Re.: SUB22-001 Lot Consolidation Application, Response to comments

This letter is in response to a comment letter dated June 30, 2023 and accompanies our re-submittal of Lot Consolidation Application on behalf of our client Xing Hua.

SW 1/4, NE 1/4,
 SEC 12, TWP 24 N, RGE 4 E, W.M.
 DWN. BY: LMK SCALE: 1"=30'
 CHK. BY: DAB JOB NO.: 2013130-08
 DATE: 6/1/23 SHEET 1 OF 3

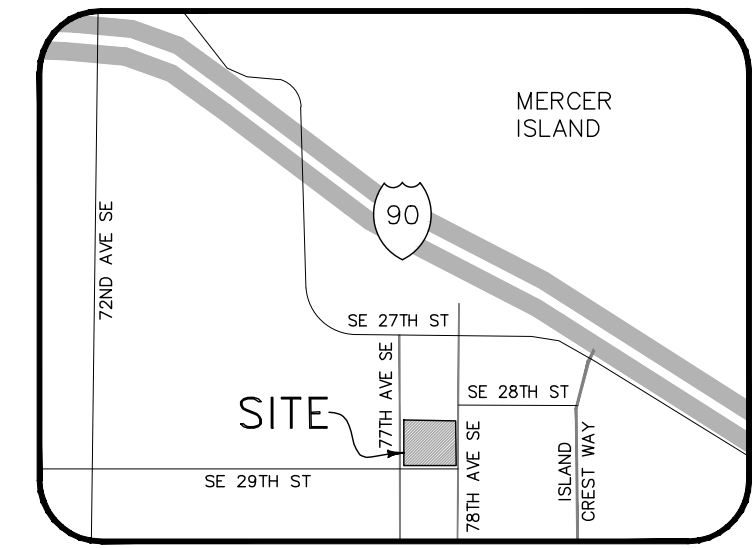
1. *Please include the 2.5-foot landscape easement (recording number 8201220491) in the list of easements on Sheet 1 of the plan set.*
2. *Several of the easement number labels on Sheets 2 and 3 of the plan set do not match the easement numbers listed on Sheet 1:*
 - *The easement labeled as number 5 on Sheets 2 and 3 (recording number 8201220491) does not have a corresponding number on the easement list on Sheet 1.*
 - *The easement labeled as number 6 on Sheets 2 and 3 (recording number 9411221152) is listed as number 5 on the easement list on Sheet 1.*
 - *The easements labeled as numbers 7 and 8 on Sheets 2 and 3 (recording numbers 9411221154 and 20050902001543) are listed as numbers 6 and 7 on the easement list on Sheet 1, respectively.*

Please correct the easement numbers on the plans so they are consistent across all sheets.

- **Items 1. And 2. have been addressed (the exception no. 5 (landscape easement) was missing in the list of easements on sheet 1, therefore some of the easement number references on the survey didn't match the easement list.**
3. *Please provide the bearing and distance of the first segment of Lot A on Sheet 3 of 3.*
 - **Missing bearing and distance are now shown.**
